From: Erika Davies
Sent: 15 July 2021 16:52
To: ENC PLANNING
Subject: FW: Planning Application NE/21/01069/FUL
Attachments: (00)001 Location and Block Plan Rev A.pdf; (08)003 Proposed Plans and Elevations Rev B.pdf

From: Erika Davies <[REDACTED]>
Sent: 15 July 2021 16:04
To: Jacob Frost <[REDACTED]>
Cc: ENC PLANNING <PLANNING.ENC@northnorthants.gov.uk>
Subject: FW: Planning Application NE/21/01069/FUL

REF NE/21/01069/FUL Single storey ancillary accommodation to replace existing single garage at Pond Yard 32, Back Lane, Collyweston, Northamptonshire, PE9 3PJ

**PROPOSED**  
Location & Block Plan

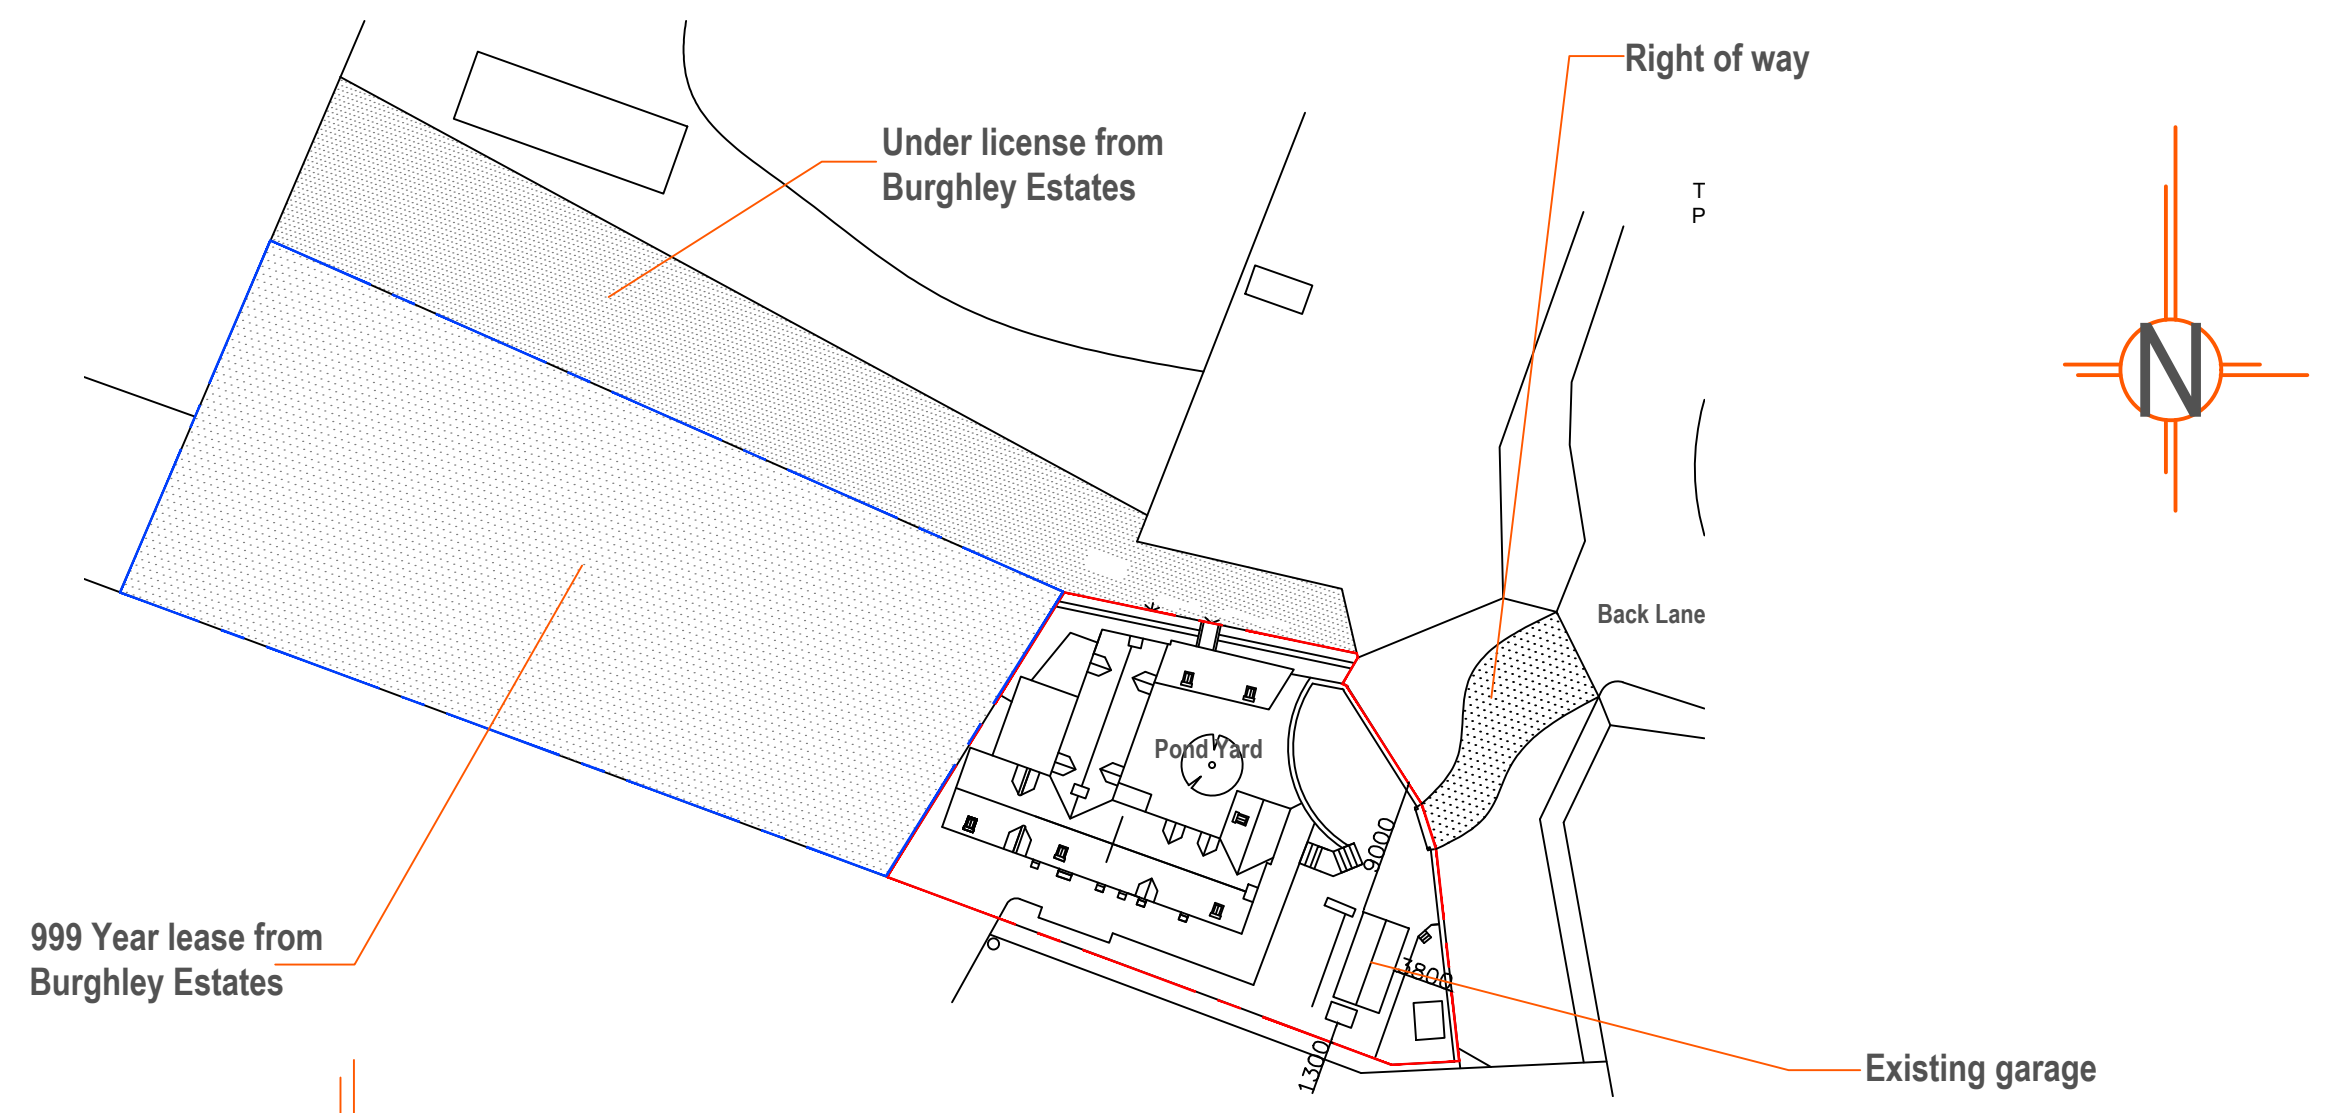
Secondly, I note that the location plan contains red lines (possibly roads?) that do not relate to the application site – these will need to be shown in a different colour, additionally the red line edging the site appears to be open in a couple of places, this red line needs to be a solid red line and also include the land required for access to the adopted highway. Also, as it appears that Ordnance Survey map data has been used in the submitted location a copyright statement on the drawing e.g. 'Contains Ordnance Survey data © Crown copyright [and database right] 2015' must be provided. Please provide an amended location plan.

Drawing
PROPOSED
Plans, Elevations
& Sections

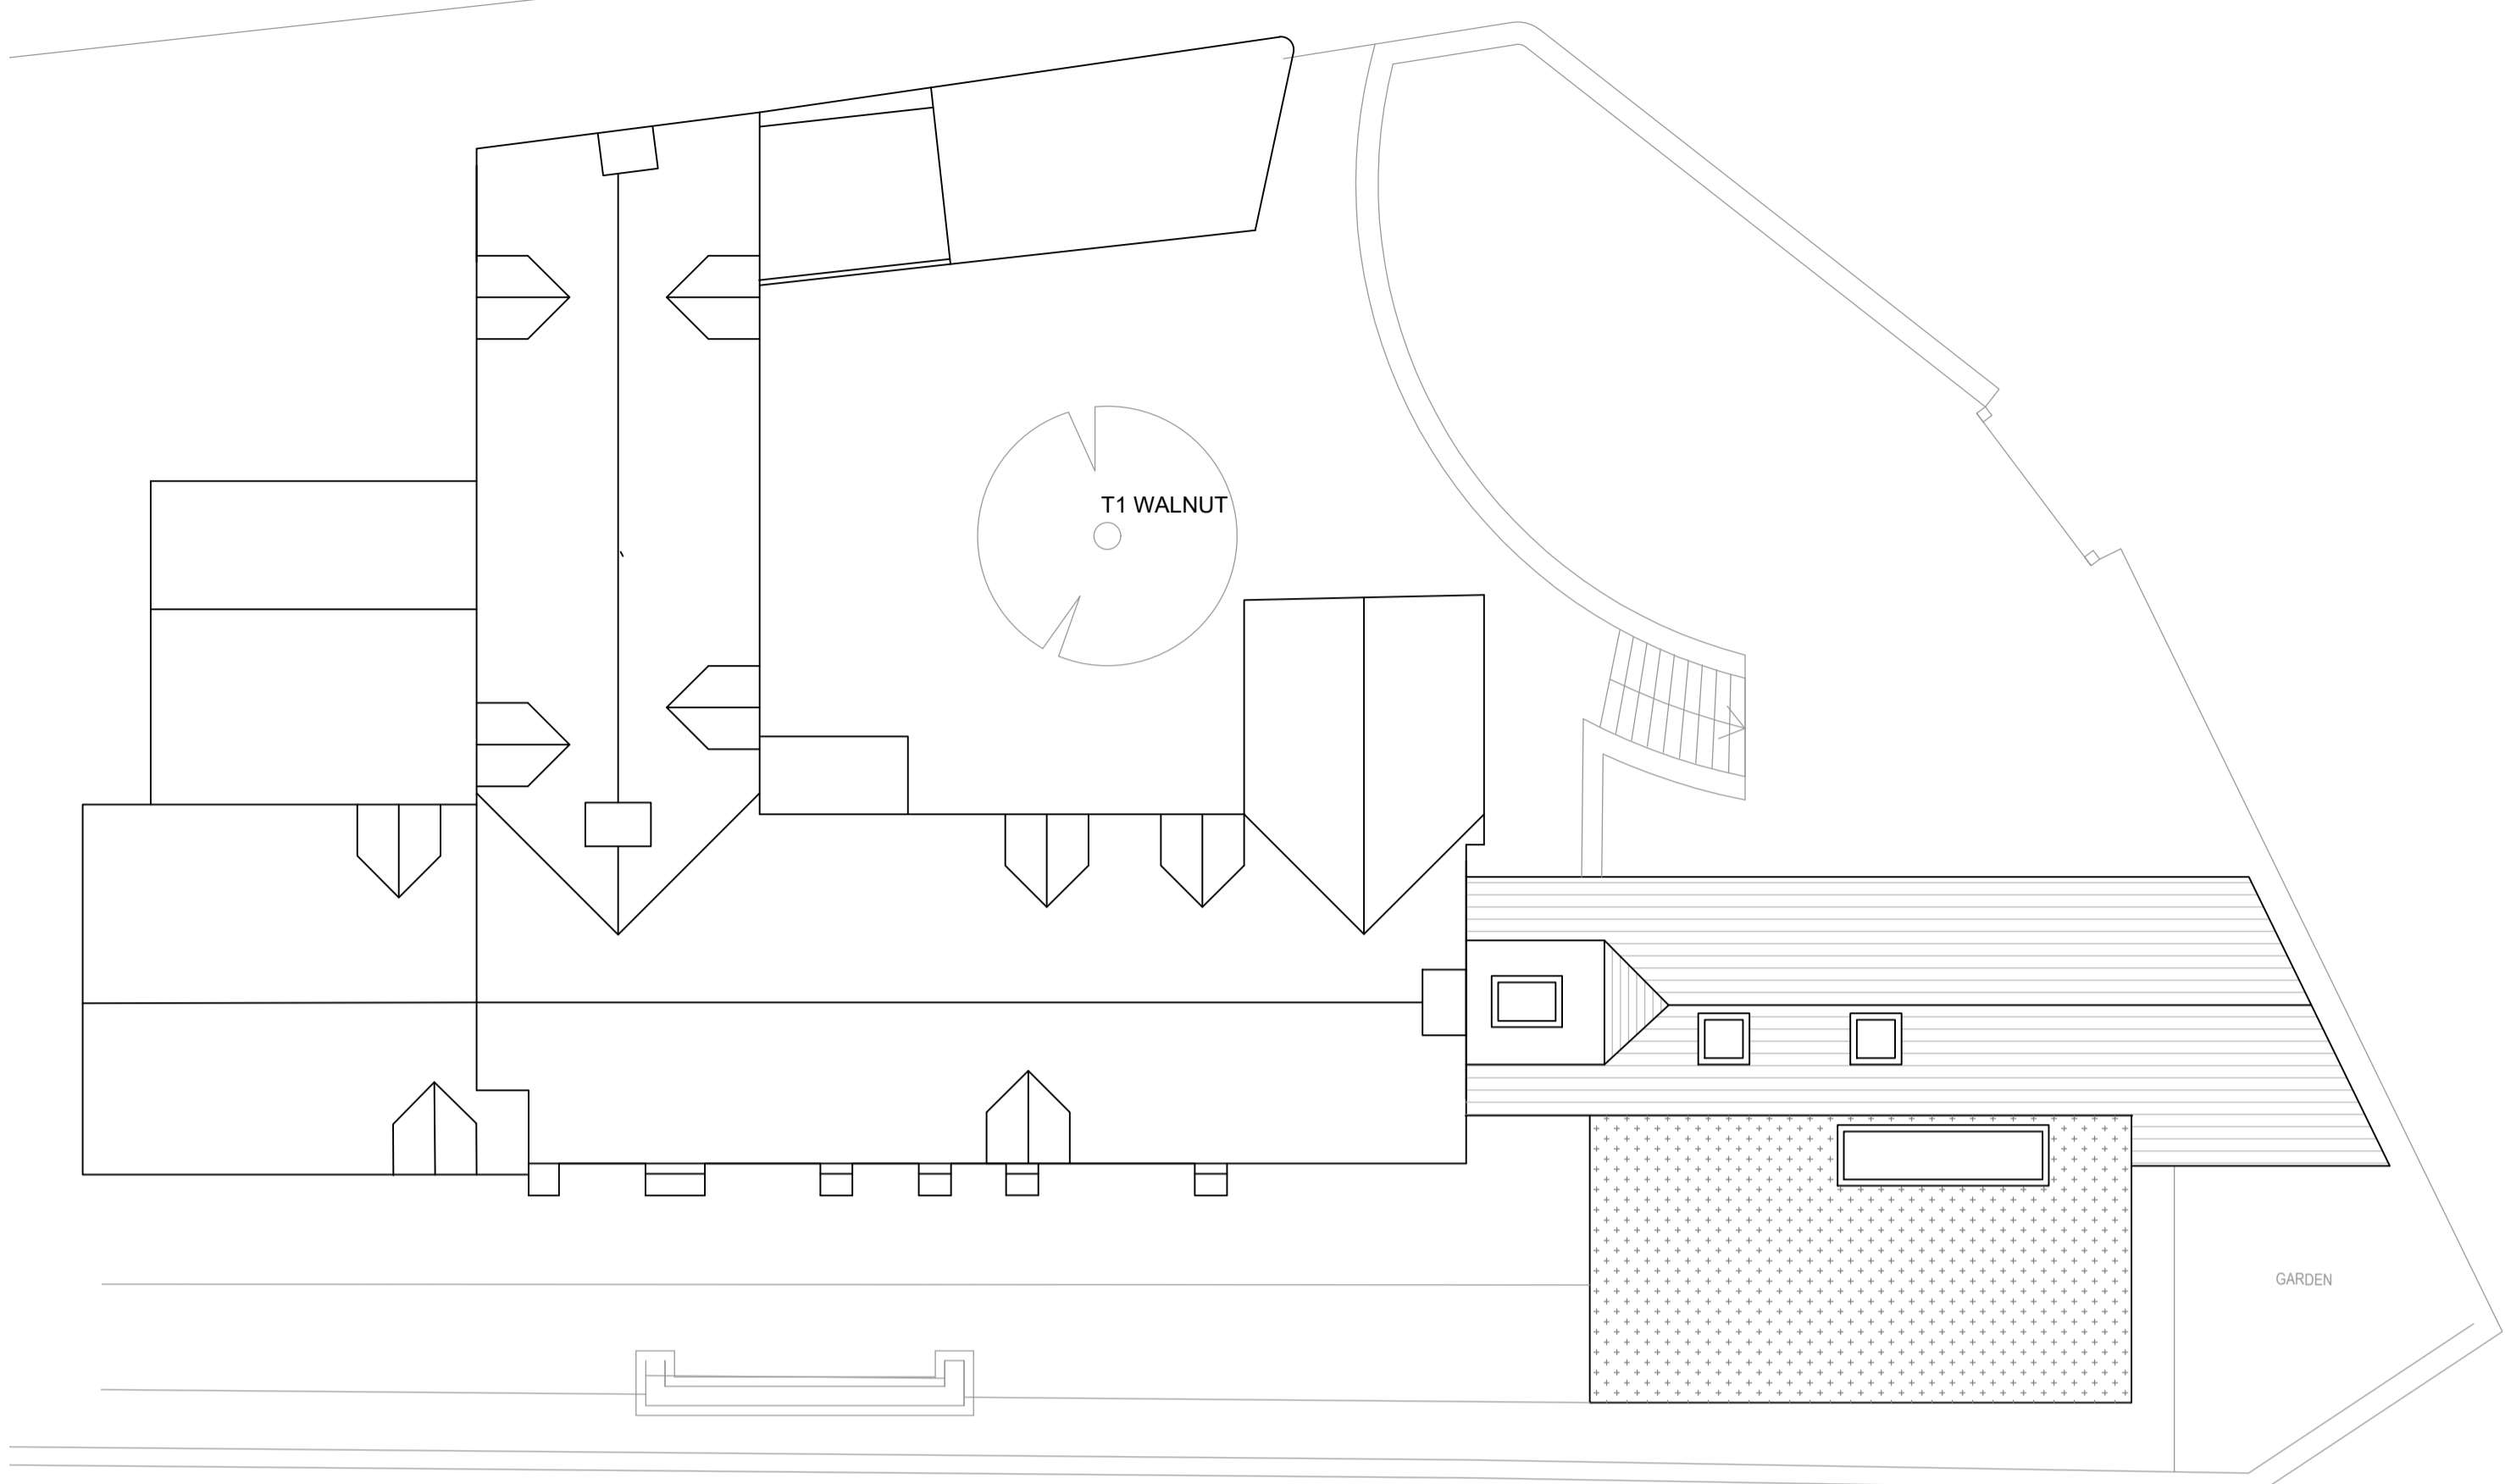
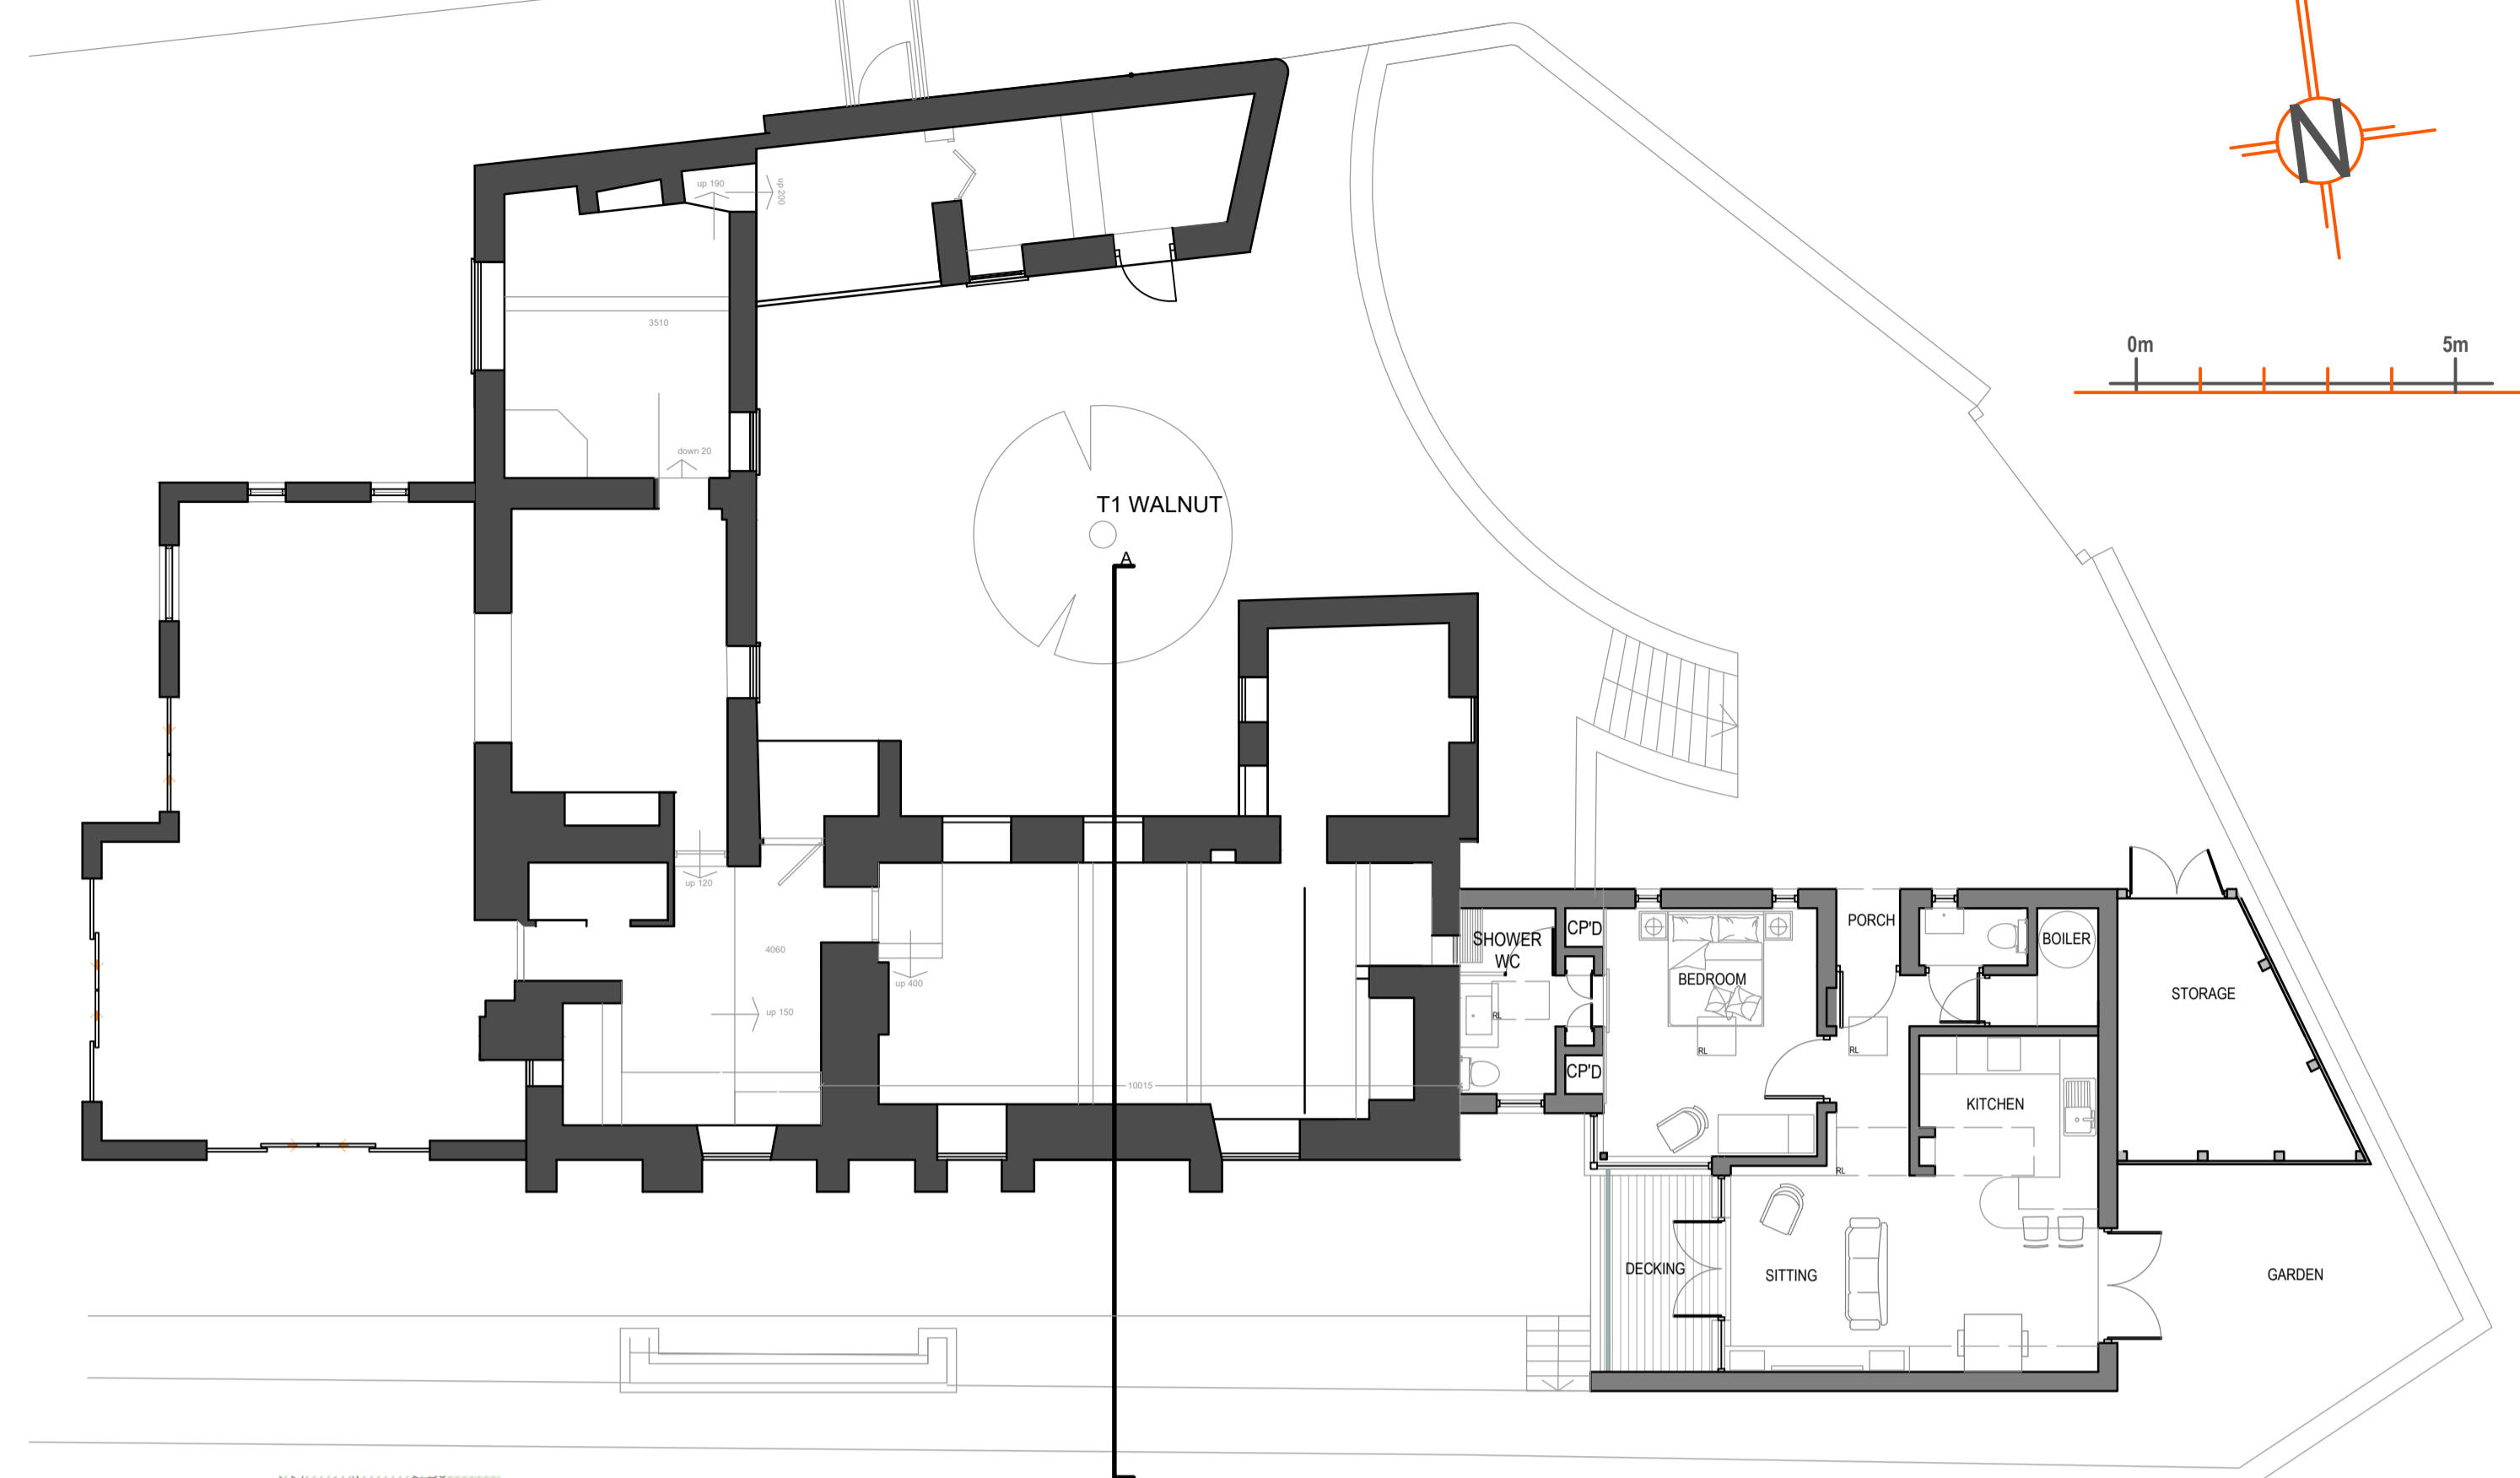
Thank you for the drawings received today, I have accepted the existing floor plans and elevations for validation, I note however that the dimension shown next to the decking on the proposed floor plan as measuring 8900 mm may be incorrect as when measured it comes to just under 4500 mm, this will need to be corrected
